7000 Acres

7000 Acres Response to the Gate Burton Energy Park Ltd Application on the subject of:

Socio-Economics and Land Use

Deadline 2 Submission – 8 August 2023

Figure 12-2 Educational Attainment

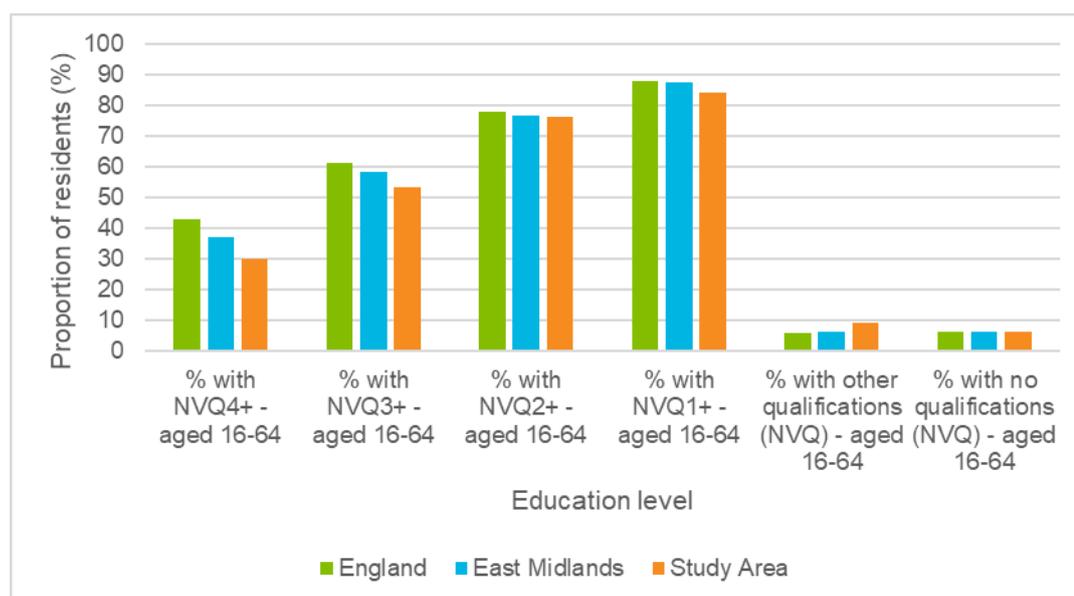
- The ES is misleading in its description of the region, in terms of economic activity, unemployment rates and education levels, concluding these are similar to those in the East Midlands and England. Considering the area with a greater level of resolution shows the significant scale of deprivation issues facing the community of Gainsborough.

In selecting such a broad area, the Applicant was able to conclude that, in most respects, the study area is broadly similar to the East Midlands and, or England as a whole, such as in relation to education, economic activity, unemployment.

It is clear, therefore that the closest town immediately associated with, and most directly impacted by GBEP development is significantly deprived in terms of income, employment, and education, which is in direct contradiction to the claims made in the ES.
